**Centennial Coal**  
Mandalong

**RE: Mandalong Mine MOD 5 – Response to Additional Information Request**

### Mandalong Mine MOD 5 - Response to Additional Information Request

Figure 6: Potential Remnant Ponding and Monitoring Locations
 Note: Proposed monitoring locations are numbered "H" to "O".

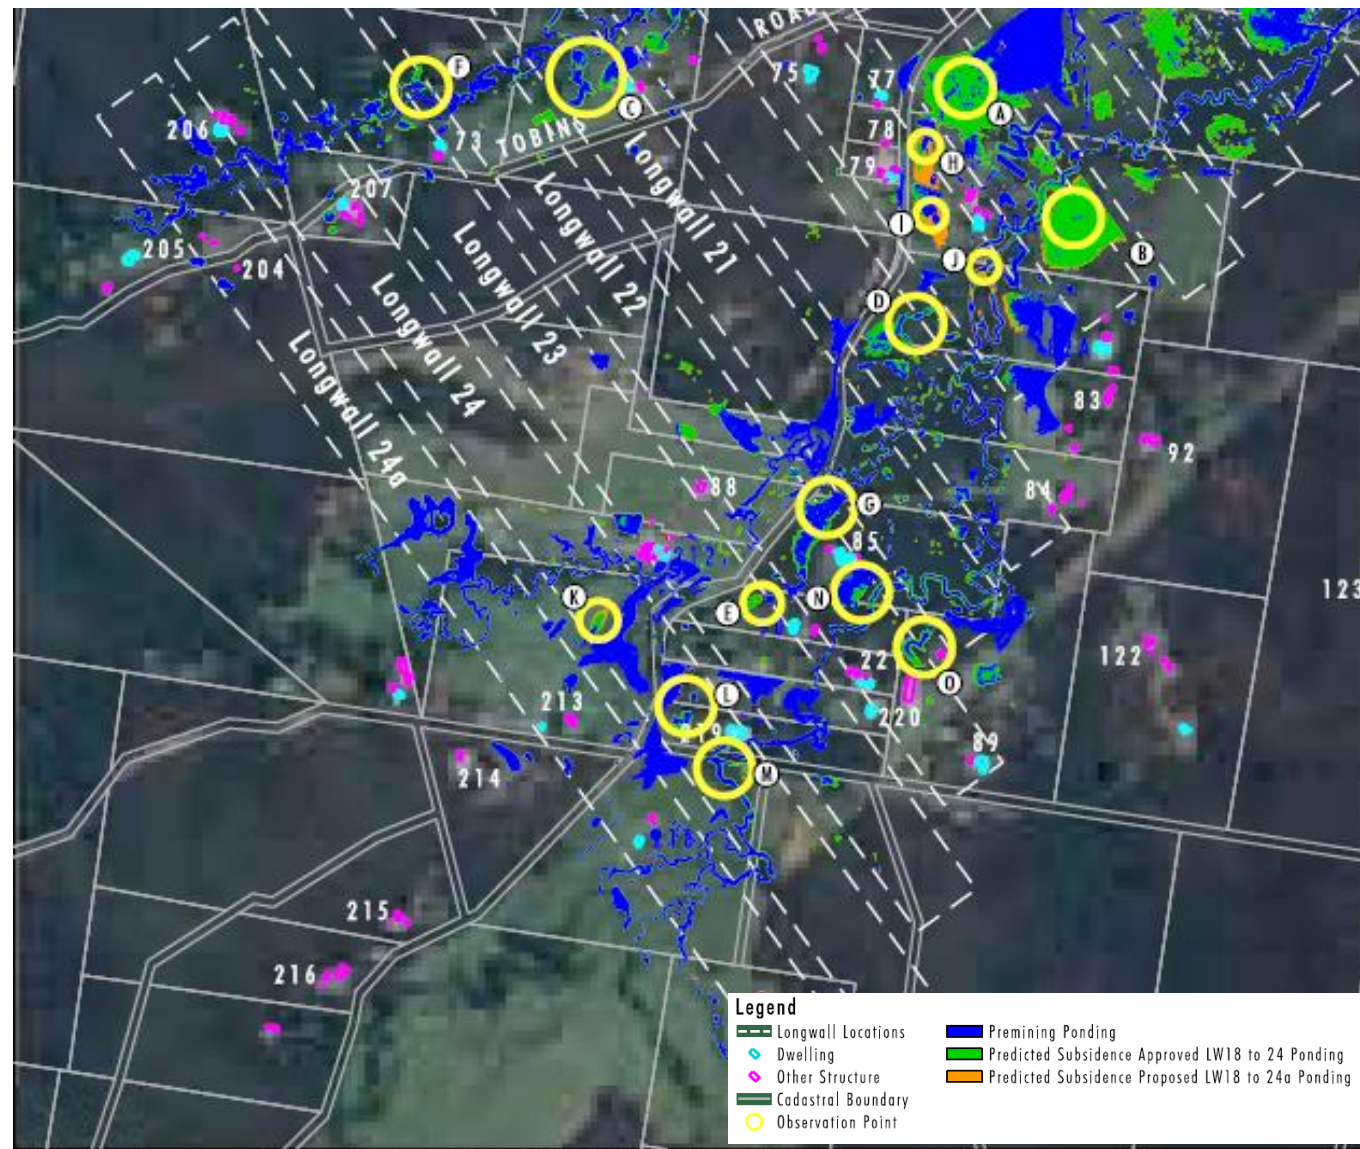
**Issue:** *The note accompanying Table 4.6 indicates that proposed monitoring locations (relevant to MOD 5) are shaded. However, there is no shading in the table. It is assumed that Locations H to O are proposed as part of MOD 5. Please confirm.*

**Issue:** *Error in Figure 35 of the Flood Assessment Report. The legend shows that predicted ponding for MOD 5 is shown in green. The 'approved' and 'proposed' colours have been switched. Request a revised Figure 35 to be provided.*

**Response:** Centennial Mandalong can confirm that the additional monitoring points, specific to Mandalong Mod 5, contained within Table 4.6 of the Flooding Impact Assessment (Umwelt 2017) are points H to O.

**Response:** A revised Figure 35 from the Flood Assessment Report (Umwelt 2017) has been attached.
